From: Liz Hutchings [REDACTED]
Sent: 12 October 2018 13:02
To: Anita Gardner
Subject: FG/140/18/DOC

Thank you, I have had a look at the revised Planting Plan 731-L01 Rev.B and have the following comments:-

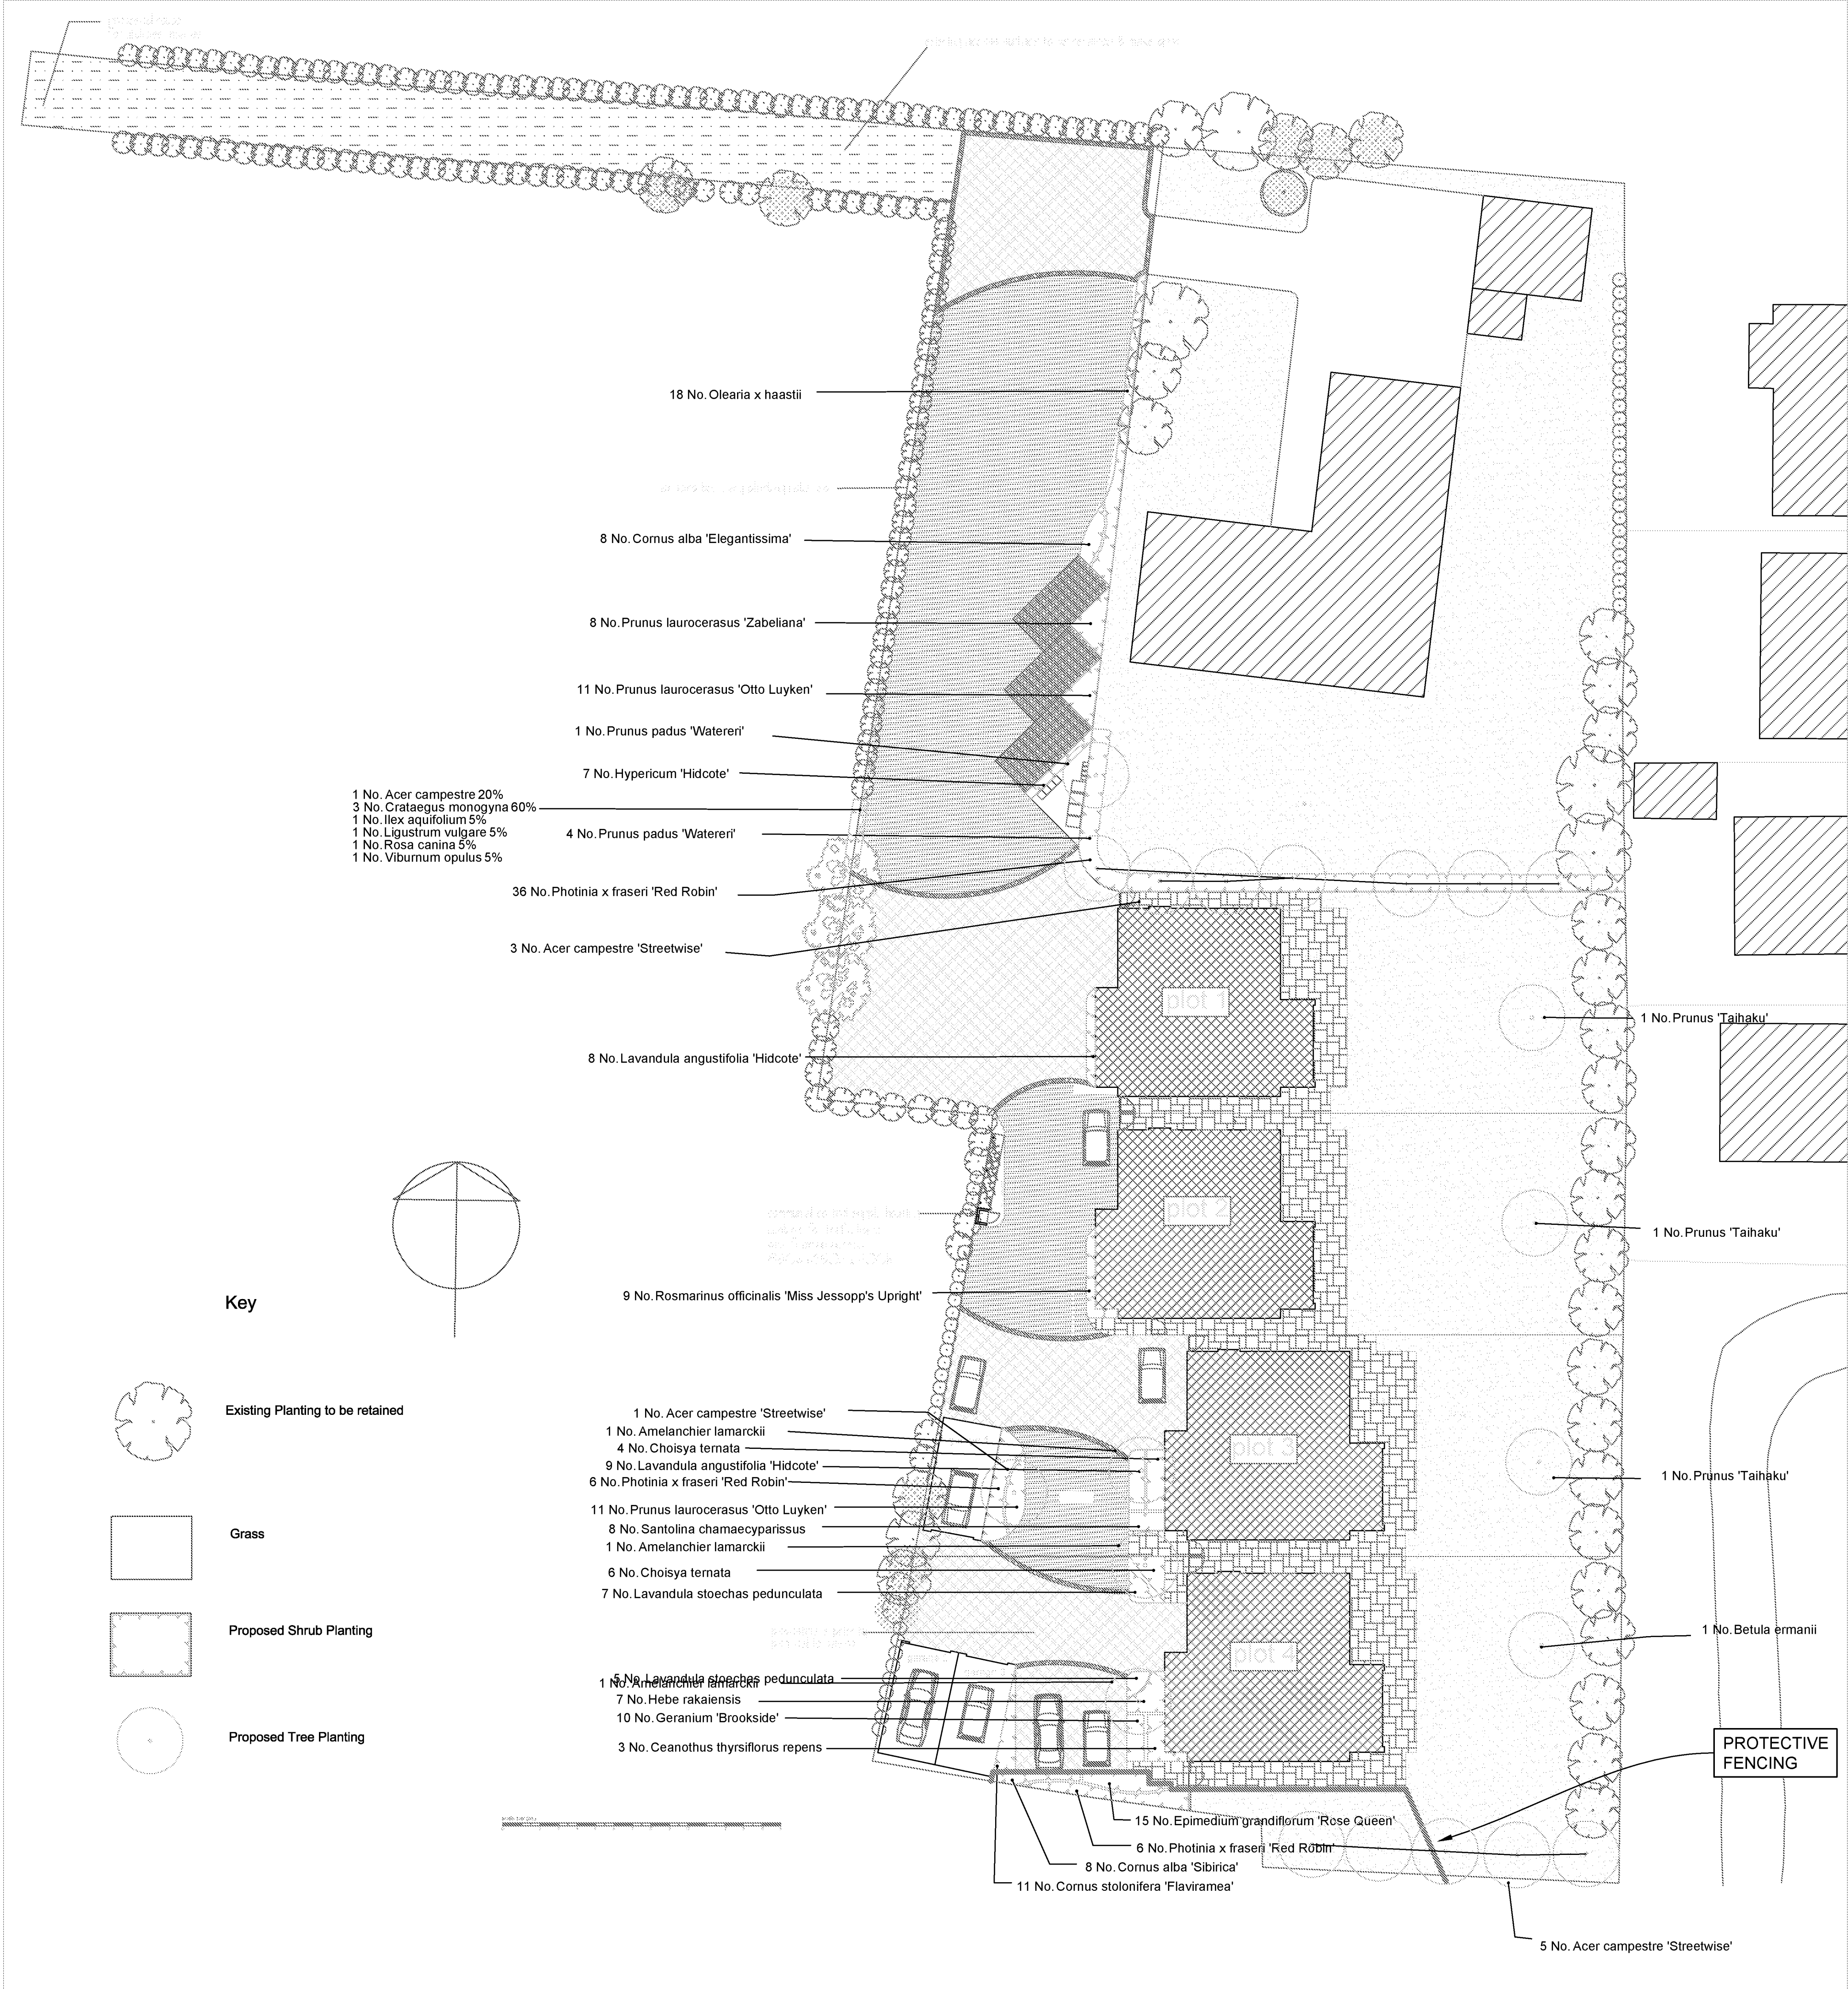
1. The hedging and shrubs lining either side of the access drive do not belong to the applicant therefore I do not see why it is on their landscaping plan.

2. The trees denoted "to be retained" along the Northern boundary similarly do not belong to the applicant, bar one small leylandii in a raised bed inside Mr.Salvidges property. There are also three trees on the plan within the western boundary of Mr.Salvidges house behind the 18 Olearia x hasstii to the right of his entrance that are not in existence OR specified as new planting?

3. The six or so Leylandi that were planted on top of the dividing privet hedge between myself at 42 and the applicants land are curiously not marked on the plan despite now having grown above legal hedge height by some 3 ft. and are intended to be left to grow into trees.

- I suggest a site visit with the landscaping planners to ascertain the situation regarding the ownership of trees they have illustrated i.e. those within Mr.Salvidges' boundary which I understand is not part of the development and therefore should not be on the plan either.
